# Rezoning Transportation Analysis

Petition Number: 2025-107

## Revision Log:

Date	Description
10-23-25	First Review (TM)
11-20-25	Second Review (TM)
12-8-25	Trip Generation Update (DR)
12-22-25	Third Review (BH)

RZ.01

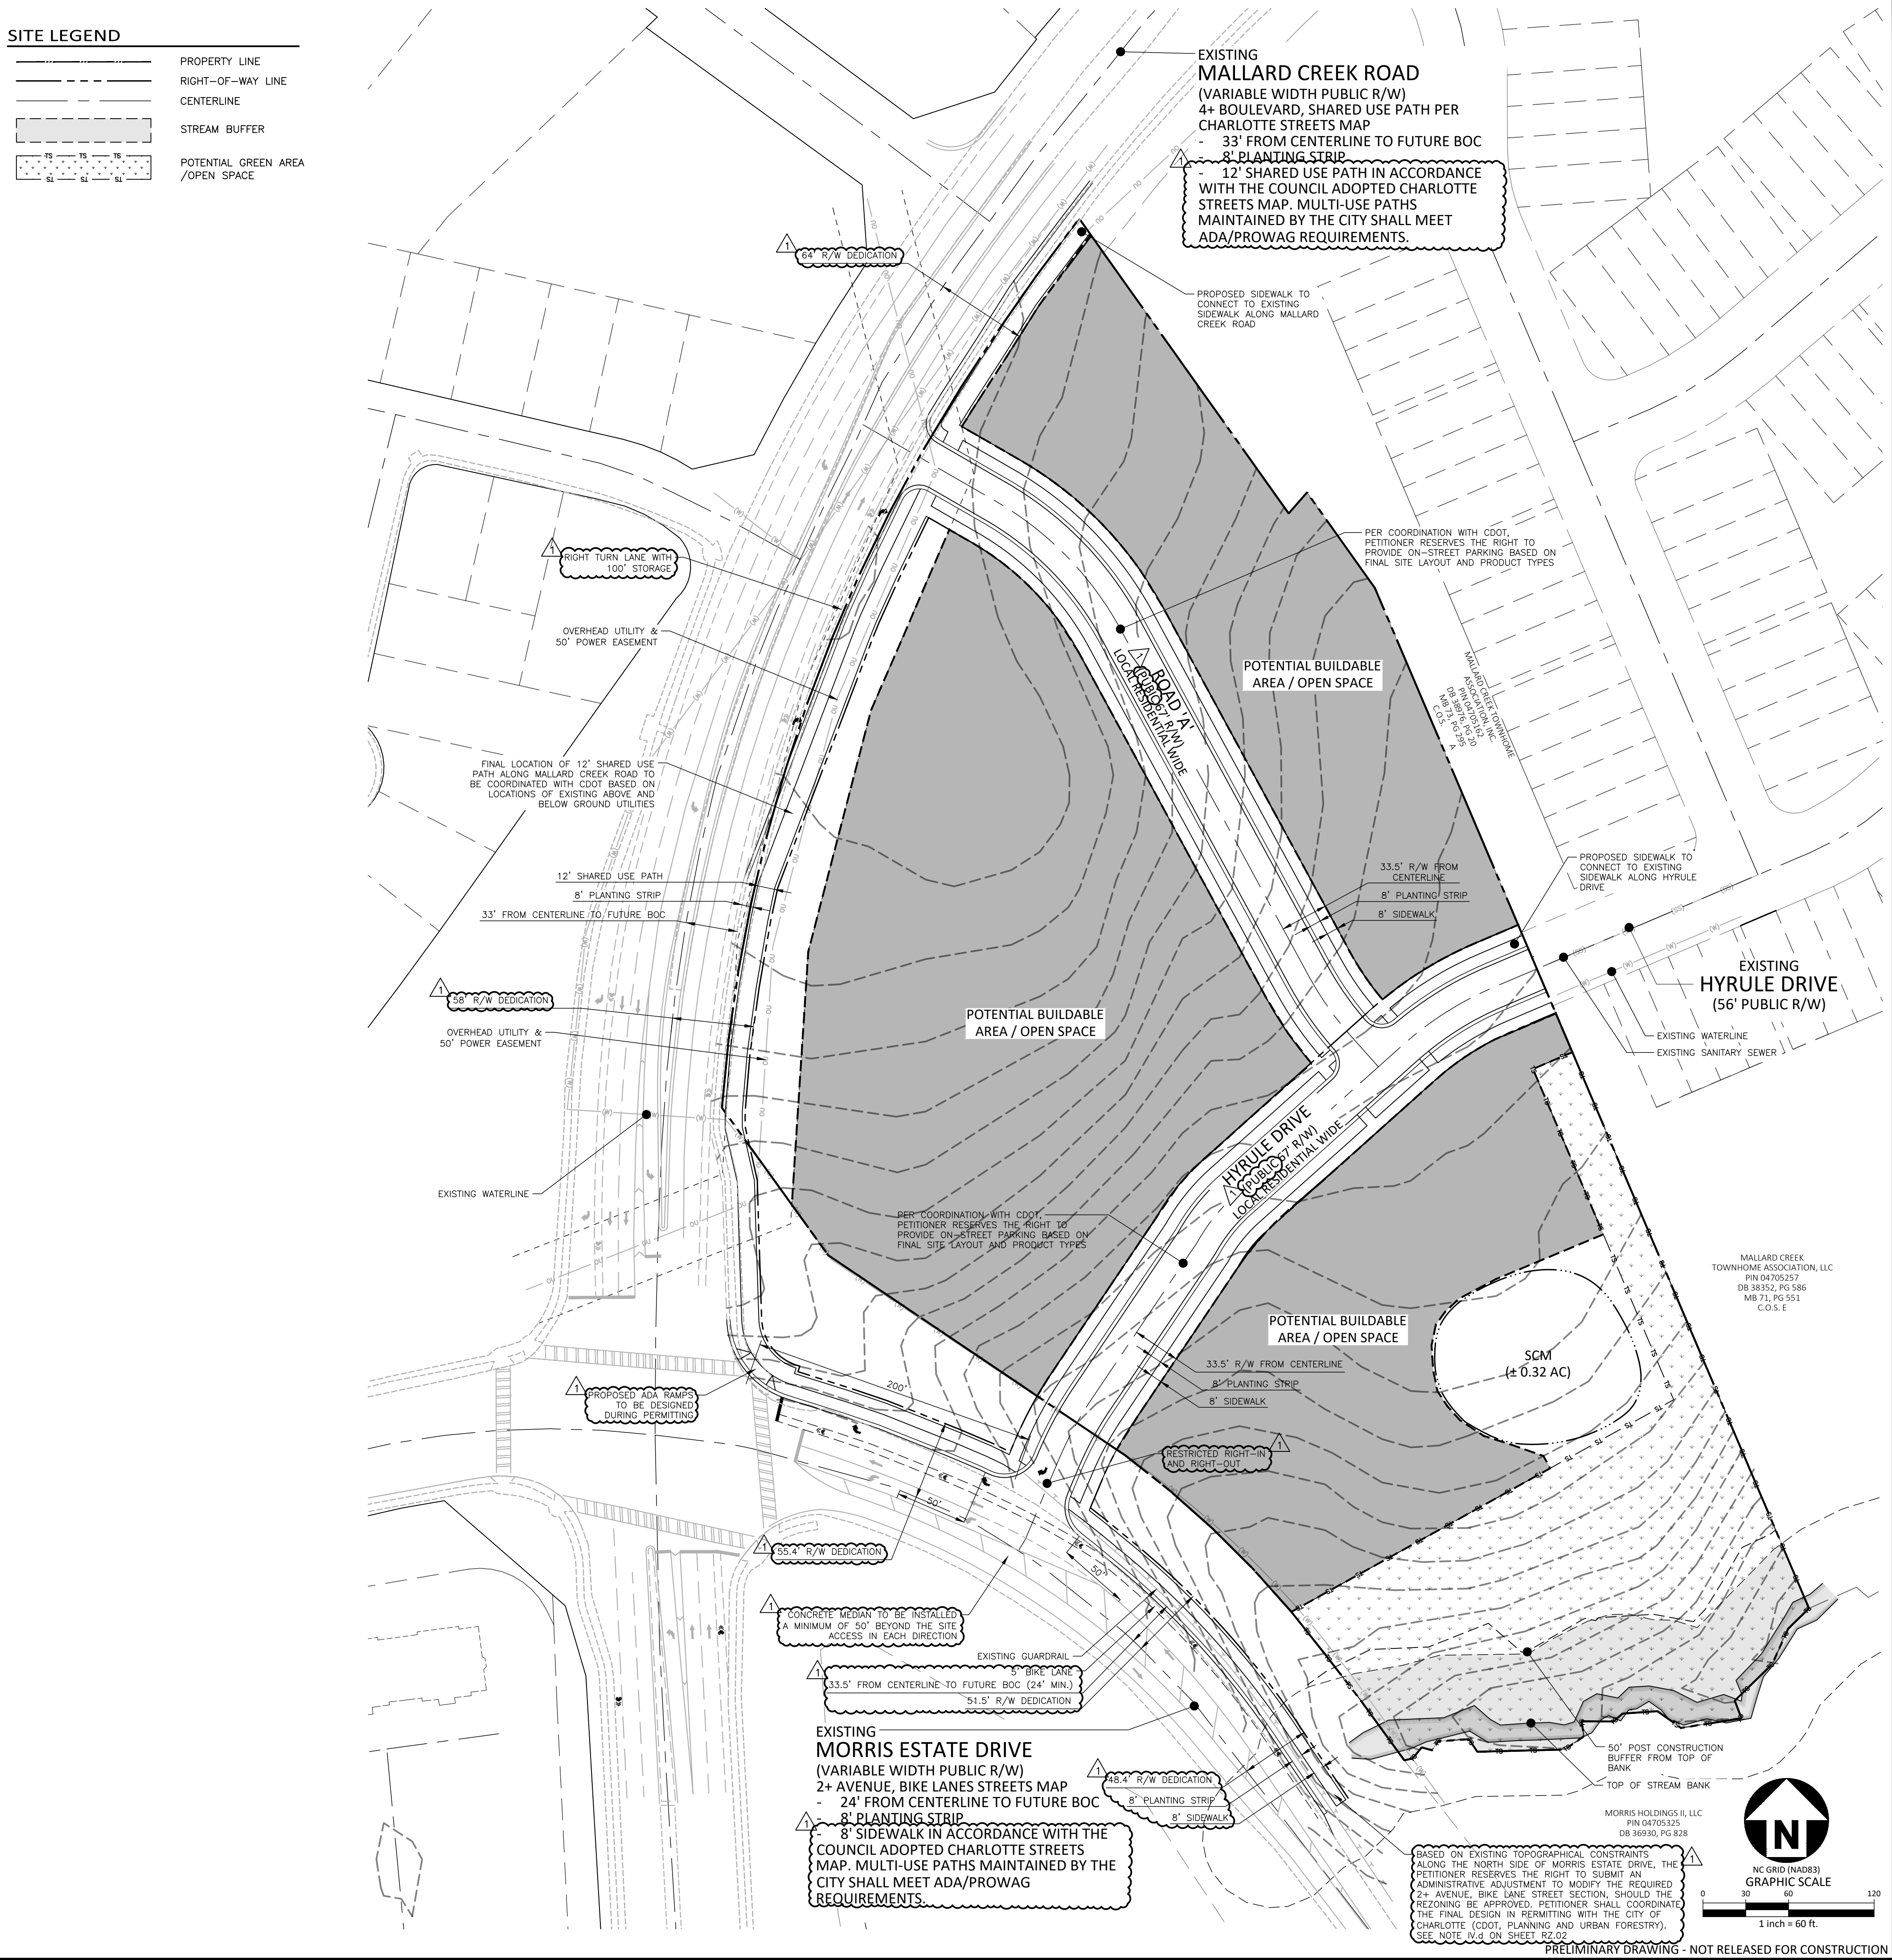
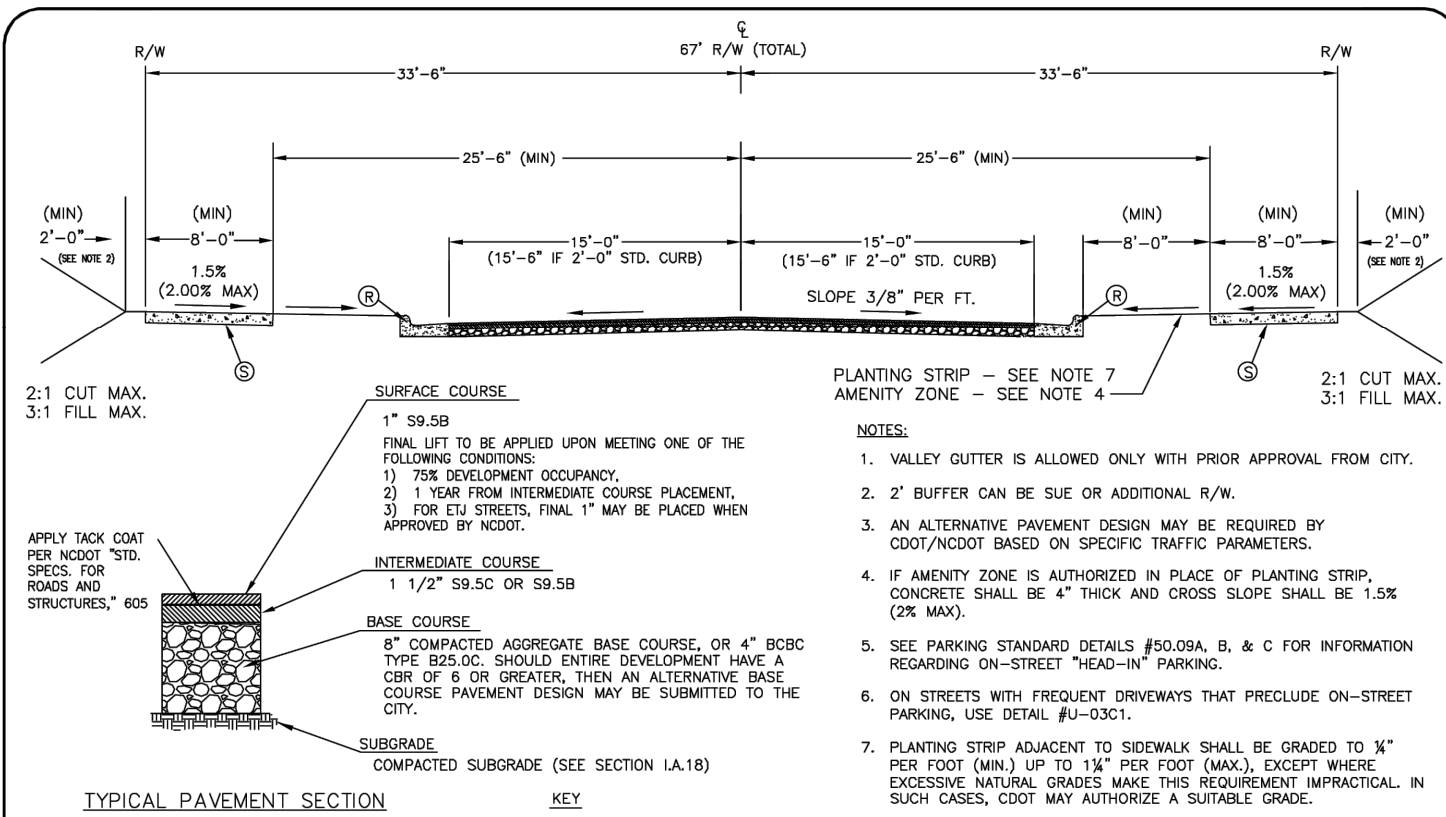
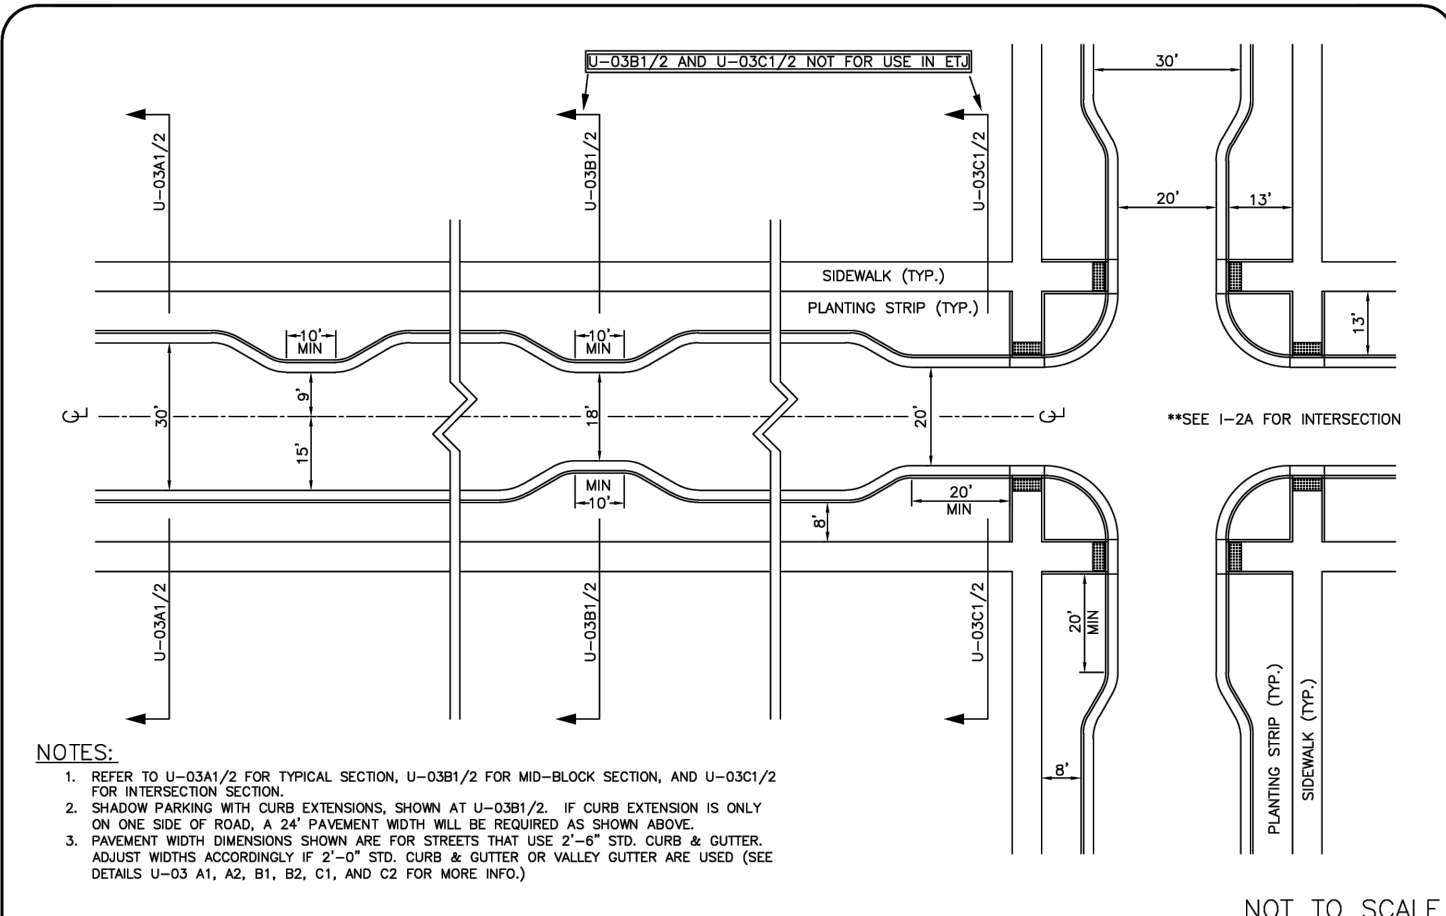
a. ~~Mallard Creek Road:~~ The future location of curb and gutter is in its existing location.

b. ~~Morris Estate Drive:~~ The future location of the back of curb is to be placed at 24-feet from the roadway centerline to accommodate the cross section of a 2+ avenue with bike lanes. This future back of curb location will vary at the intersection with the addition of a turn lane and other intersection geometry features.

~~Label and dimension the curb and gutter from the centerline for each road on the site plan.~~

- ~~3. Revise site plan and conditional note(s) to commit to a min dedication of 42 feet of right-of-way from the road centerline along Morris Estate Drive (Placing the right-of-way 2 feet behind sidewalk). IF existing ROW exceeds this minimum amount then ROW shall remain in its existing location. The site plan shall label and dimension the right-of-way from the road centerline to 2 feet behind the sidewalk.~~

- ~~4. Revise site plan and conditional note(s) to commit to a min dedication of 55 feet of right of way from the road centerline along Mallard Creek Road (Placing the right-of-way 2 feet behind the shared use path). IF existing ROW exceeds this minimum amount then ROW shall remain in its existing location. The site plan shall label and dimension the right of way from the road centerline to 2 feet behind the shared-use path.~~

- ~~5. Revise site plan and conditional note(s) to commit to construct bicycle facilities by installing a 12-foot multi-use path in accordance with the council-adopted Charlotte Streets Map on Mallard Creek Road. Multi-use paths maintained by the City shall meet ADA/PROWAG requirements.~~

- ~~6. Revise site plan and conditional note(s) to commit to construct bicycle facilities by installing a 8-foot sidewalk in accordance with the council-adopted Charlotte Streets Map on Morris Estate Drive. Sidewalks maintained by the City shall meet ADA/PROWAG requirements.~~

11. ~~Revise site plan and conditional note(s) to commit to restricting access to Morris Estate Drive to a Right-In Right-Out (RIRO) access. A concrete median shall be installed from the intersection of Mallard Creek Road and Morris Estate Drive to 50 feet beyond the site access (measured from the curb return on the plan east side of the Morris Estate Drive site access). Median shall also accommodate existing roadway infrastructure. Site plan shall show existing turn lanes and other infrastructure. Add dimensions and callouts to the site plan committing to this improvement. In addition add conditional note(s) describing this improvement and committing to this access point being RIRO.~~

12. ~~Revise site plan and conditional note(s) to commit to constructing a right turn lane (RTL) on Mallard Creek Road per NCDOT requirements. Site plan shall show RTL with 100 feet of storage at the intersection of Mallard Creek Road and "Road A". Design to be finalized during permitting in coordination with NCDOT and CDOT.~~

13. ~~Revise site plan and conditional note(s) to commit to installing an 8 foot planting strip and an 8 foot sidewalk along the Morris Estate Drive roadway frontage. Site plan is to label and dimension from the roadway centerline.~~

14. ~~Revise site plan and conditional note(s) to commit to constructing curb line in the future back of curb location in accordance with the UDO and the council-adopted Charlotte Streets Map. Curb and gutter to be placed at a min of 24-feet from the roadway centerline. Site plan shall dimension the curbline from the roadway centerline to the FBOC location. Add a conditional note committing to this improvement.~~

15. ~~Revise site plan and conditional note(s) to commit to removing the mid-block pedestrian ramps and adding ramps at the intersection of Road A and Hyrule Drive.~~

16. ~~Revise site plan and conditional note(s) to commit to providing ADA ramps at the intersection of Morris Estate Drive and Mallard Creek Road. Final design of ada ramps to be designed during permitting. Show 2 ramps on the site plan and add conditional note(s) to the conditional note(s) committing to this improvement.~~
